RE: 119 E. Kidder Street – 425-I-part of 28, 31, & 32 – R-5 Zone – application #050-506

I am in receipt of your application to split the current lots that you own into two separate lots and to then build a new two unit building on the newly created lot. Your permit has been denied because your submittals are incomplete at this time in order to determine compliance with the City's ordinances.

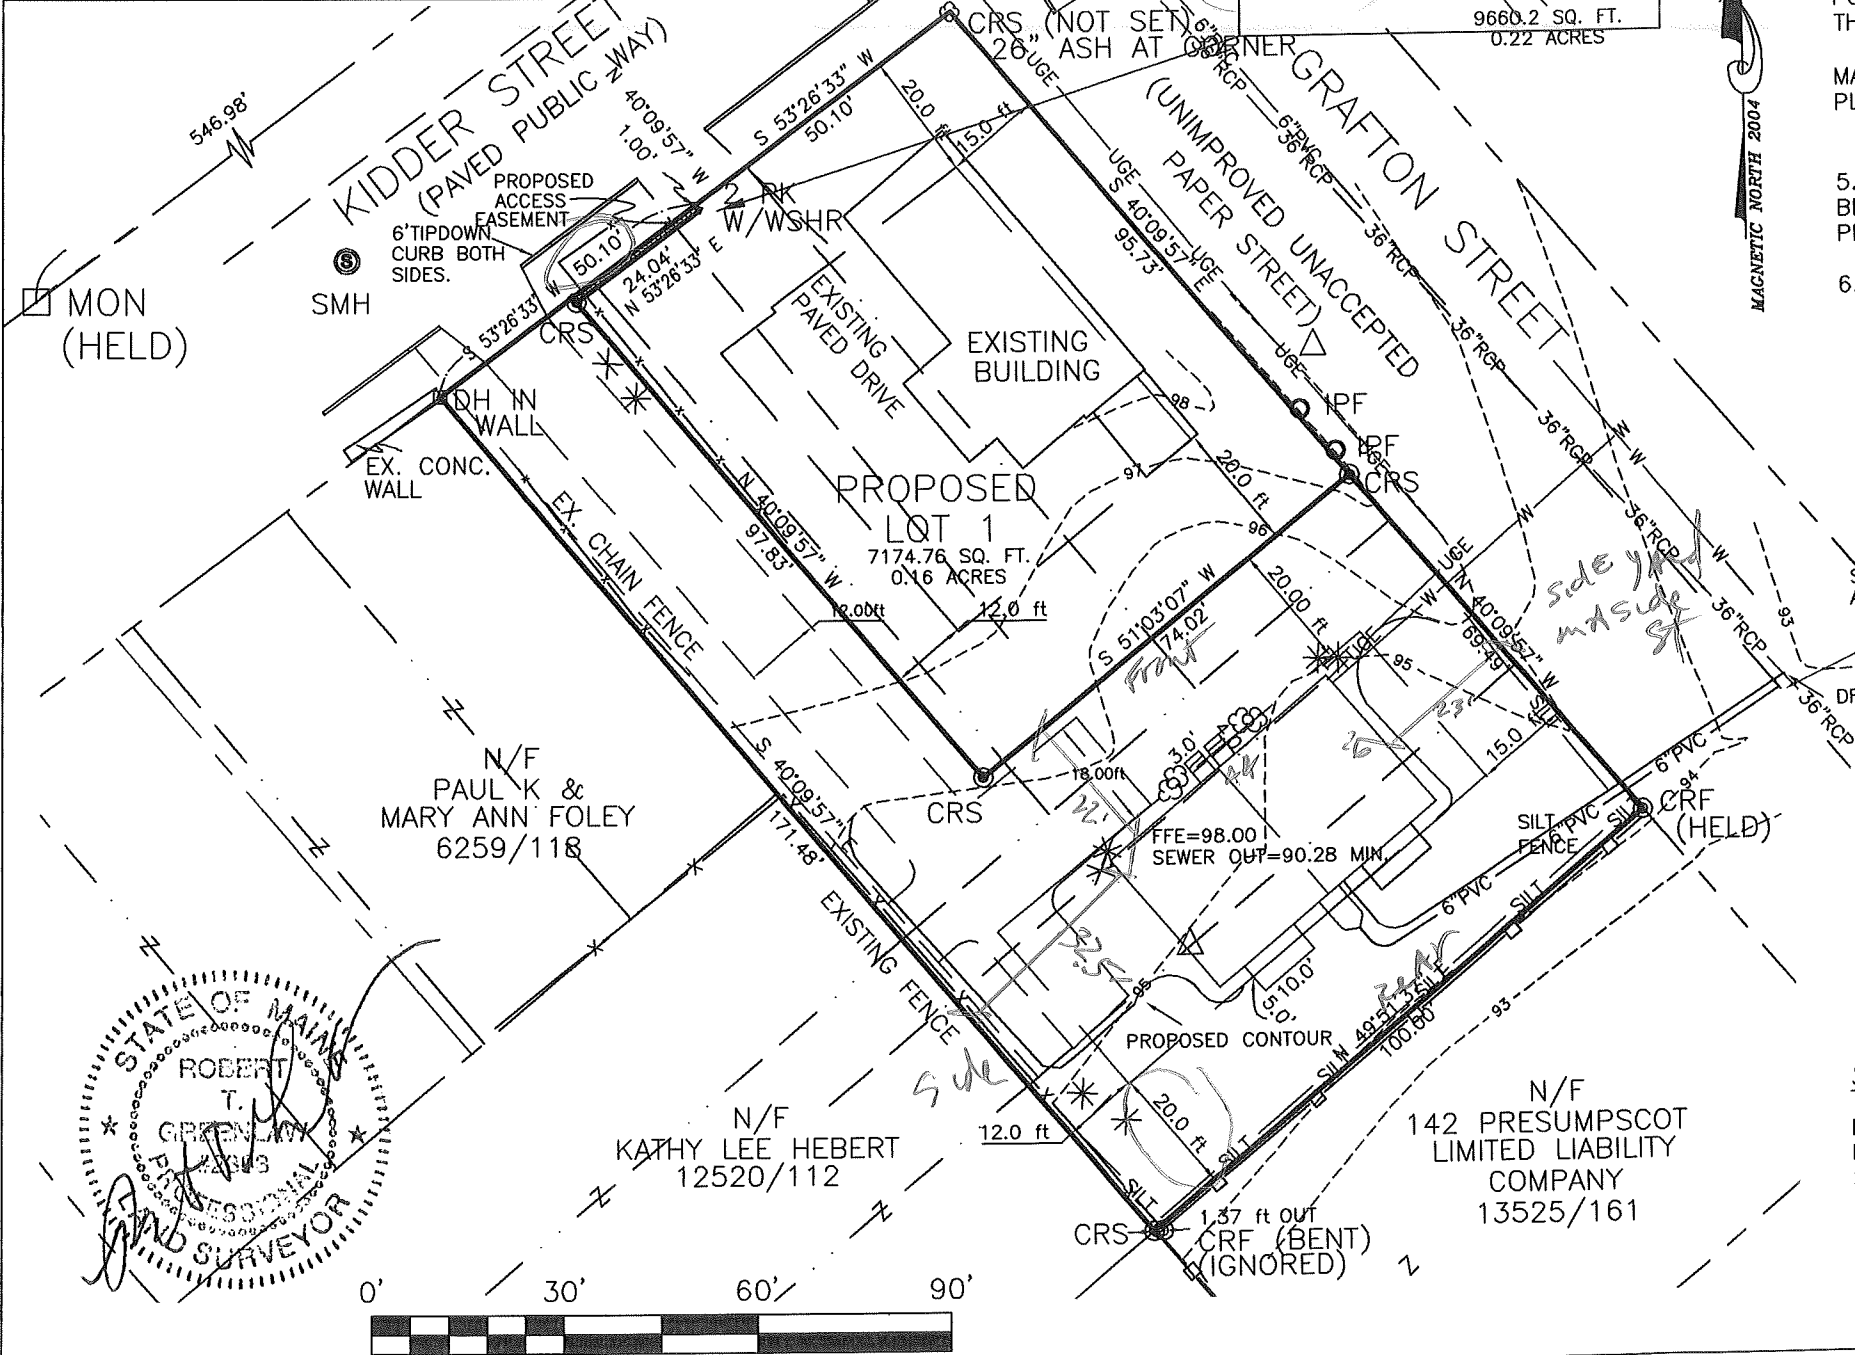
Your submittal has not shown the required four (4) parking spaces on your plans. You need to provide four 9'x19' parking spaces. These parking spaces shall not be places within your required front yard setback.

Your site plan does not entirely match your building plans. Your building plans show two 5' x 10' rear decks with stairs extending toward the rear setback line. Your site plan does not show those extended stairs. It is important to show the exact dimension of the stairs. Your allowance to project into a required yard is limited to no more than 50 square feet, with a projection of no more than six (6) feet (section 14-425). Your proposal may be violating that allowance.
